Application no: **3/2022/1161**

Address: **The Coach House Hodder Street Longridge PR3 3JB**

Proposal: **Proposed enclosed car port.**

The Coach House Driveway Alterations		Drwg No.	Rev.
Proposed Plan & Elevations		A3900-PL02	
		Scale	Sheet Size
		As Shown	A1

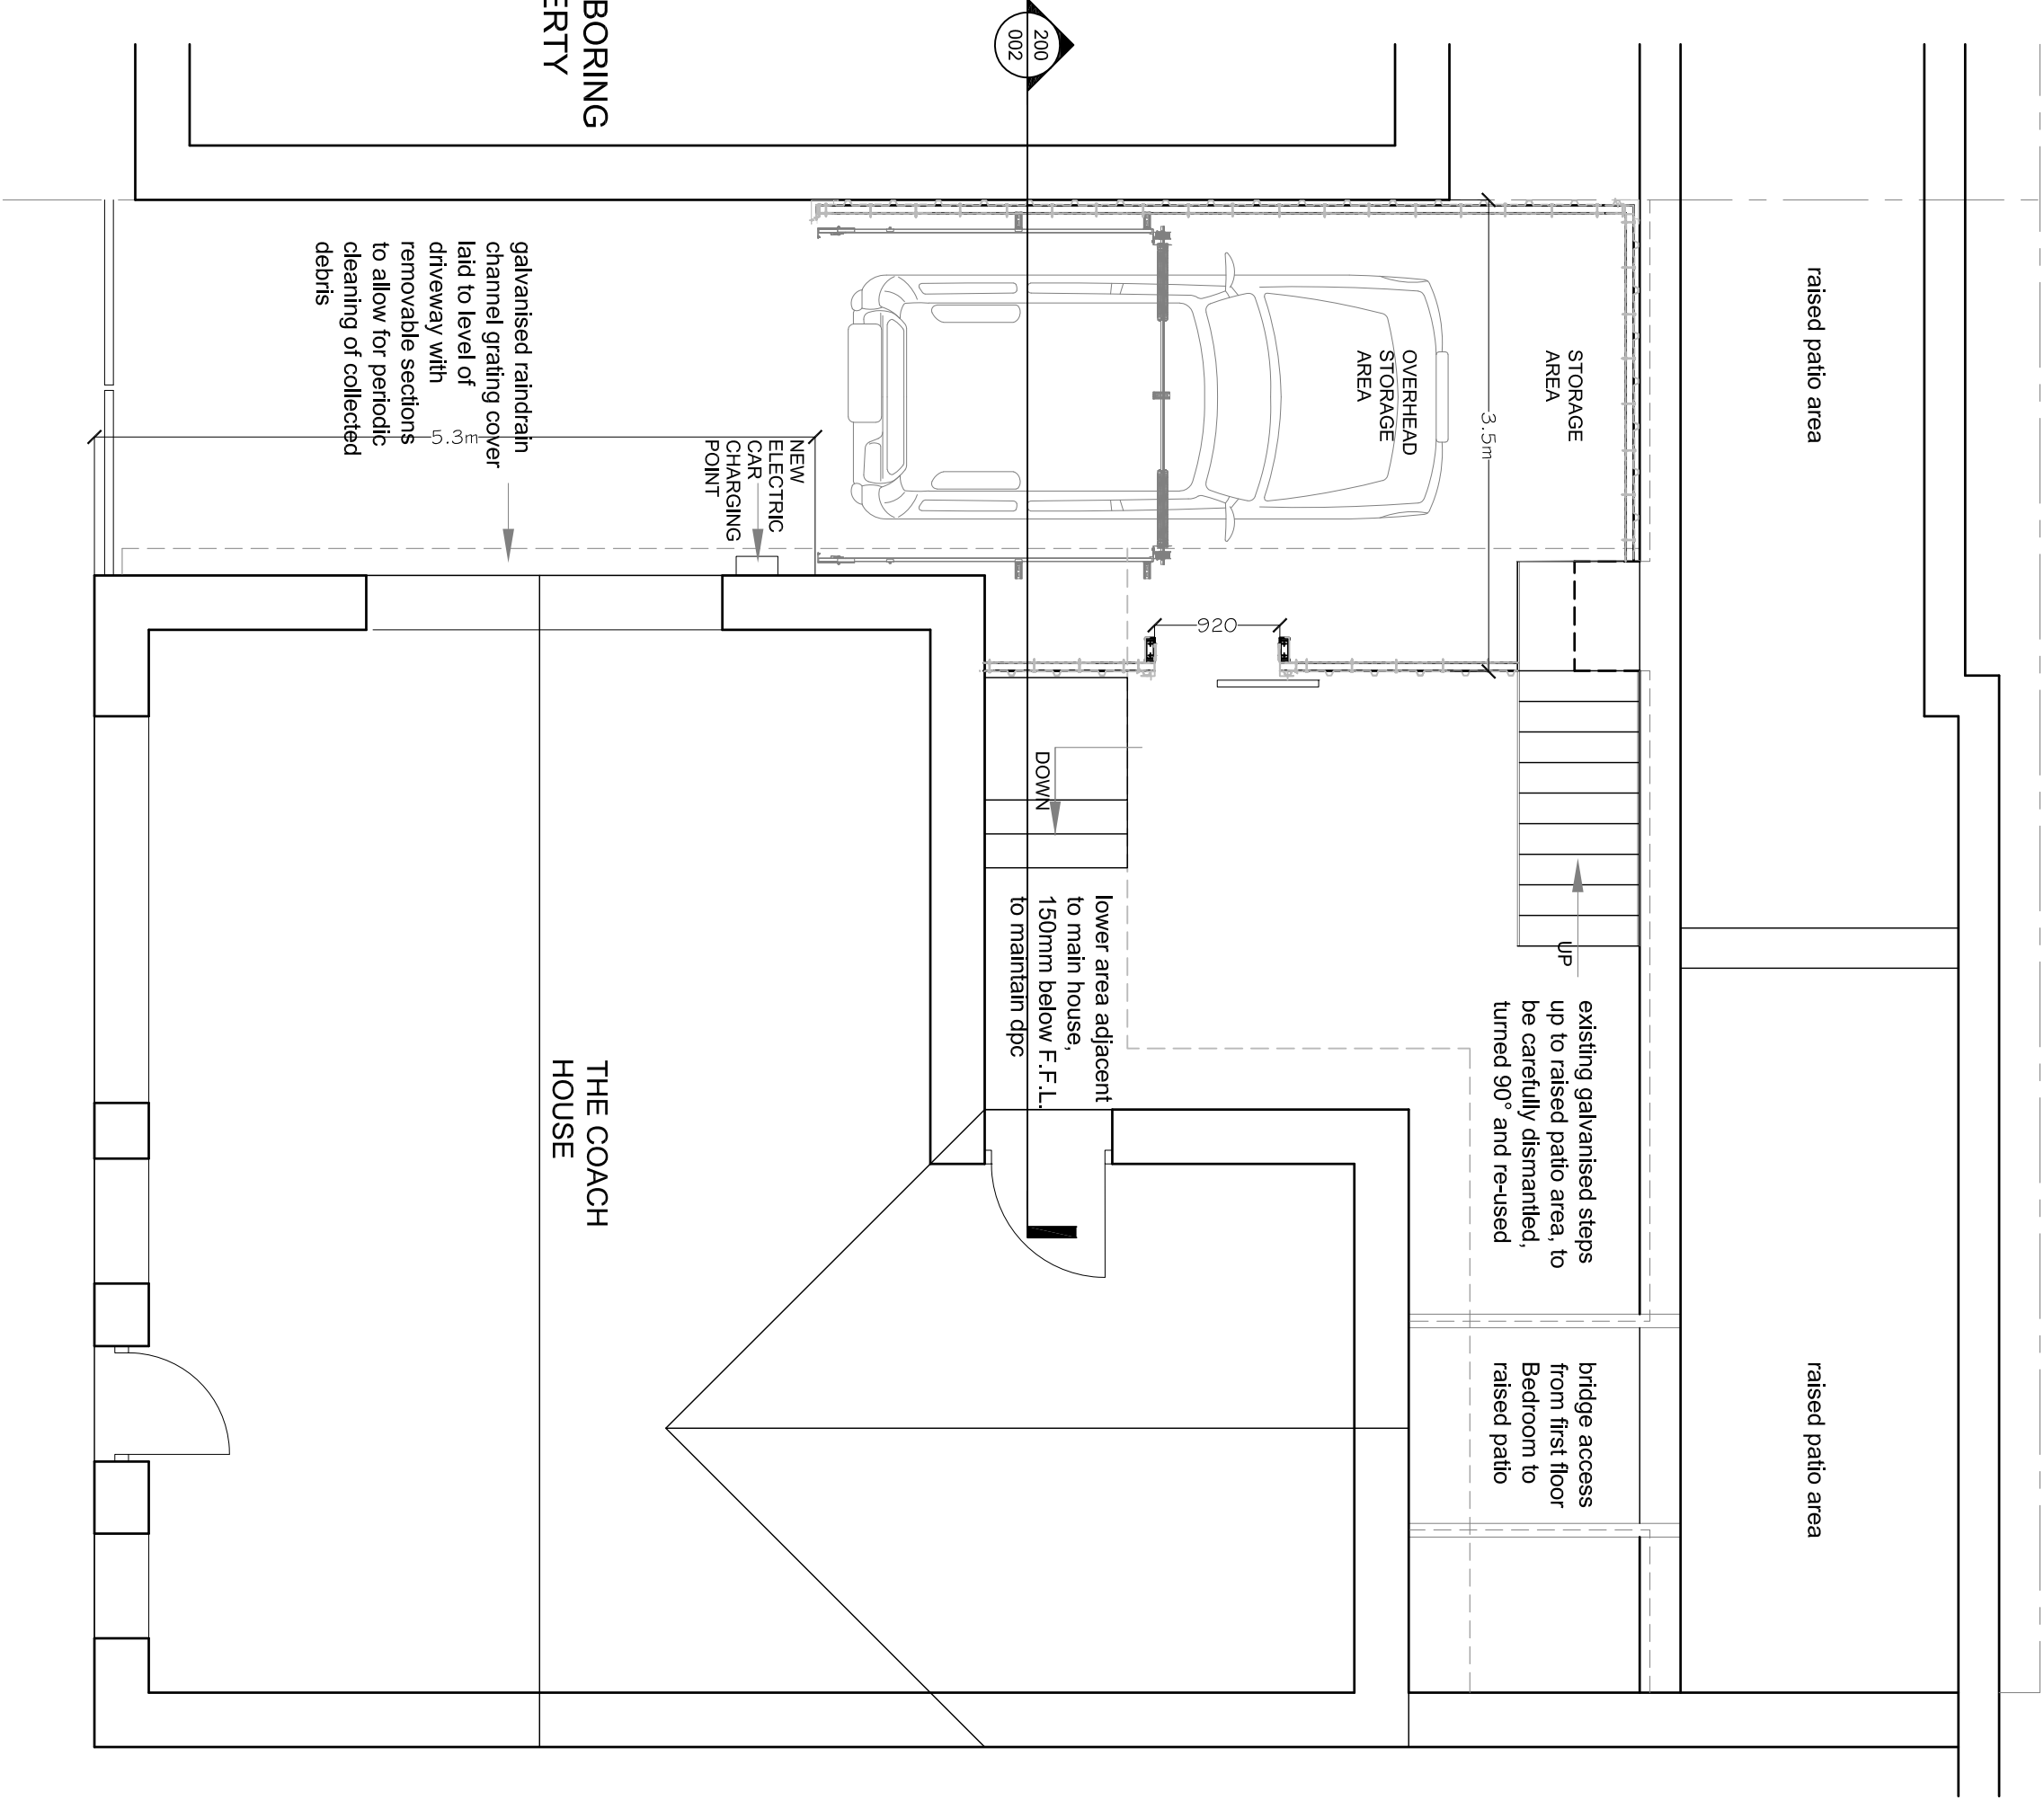
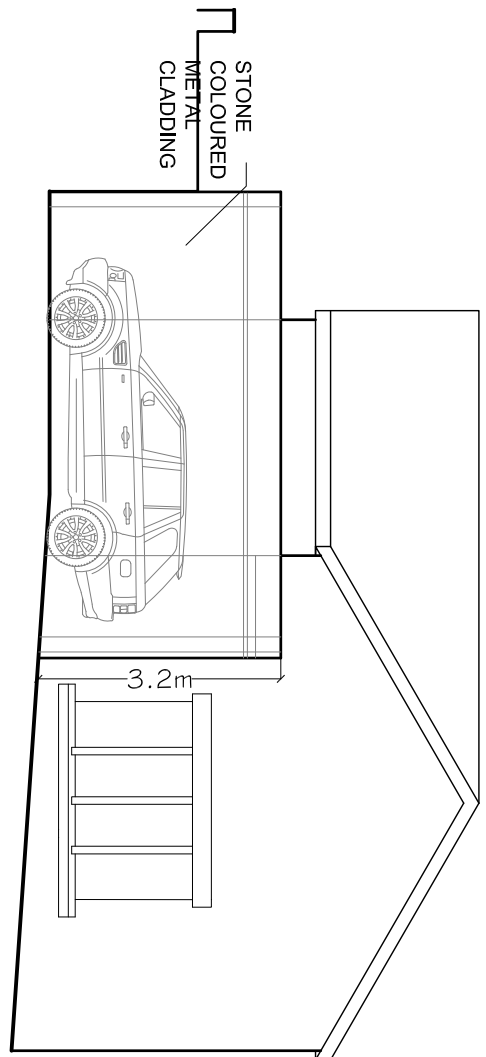
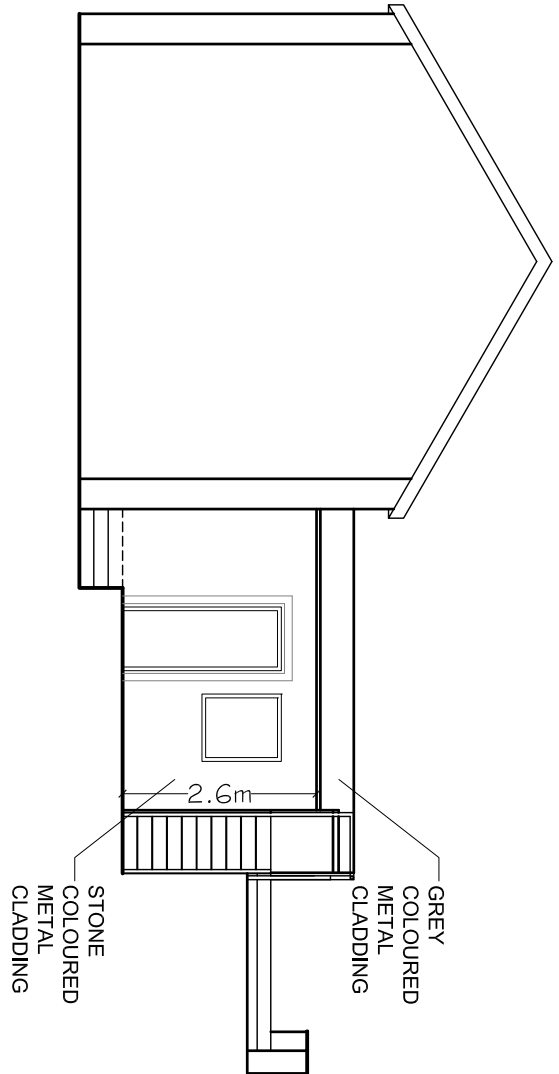
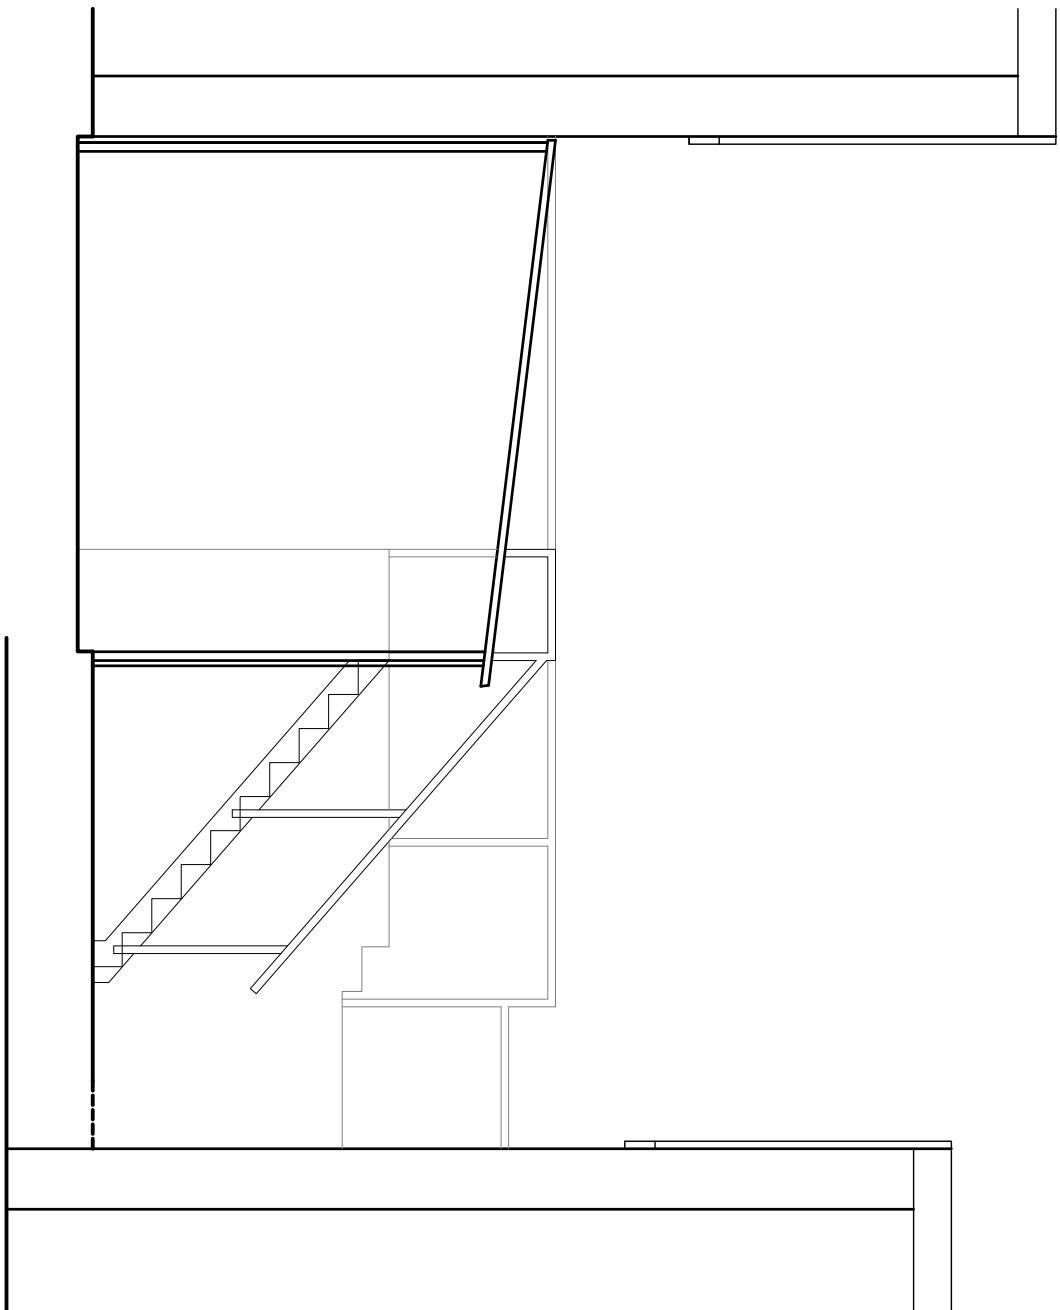
In any case the LHA have reviewed PSA drawing number A3900-PL02 titled "Proposed Plan and Elevations" and are aware that the dimensions of the car port will be 3.5m wide which eventually reduces to approximately 2.7m and will be approximately 6m in length.

Usually, the LHA require a garage serving one car parking space to be the minimum of 3m wide for the duration of its length to ensure that a vehicle can use the garage. However,

given that the garage will be located off a private, unadopted access track the LHA will accept the shortfall.

Furthermore, the LHA require the setback distance of the garage doors and the start of the access to be 6m to ensure that there is adequate space to operate the garage doors without obstructing the highway.

However, despite the setback distance only being 5.3m, as shown on the drawing, the LHA will accept the shortfall with the dwelling being accessed off a private, unadopted access track and is unlikely to have a detrimental impact on the adopted highway. Therefore, the LHA have no objection to the proposal.
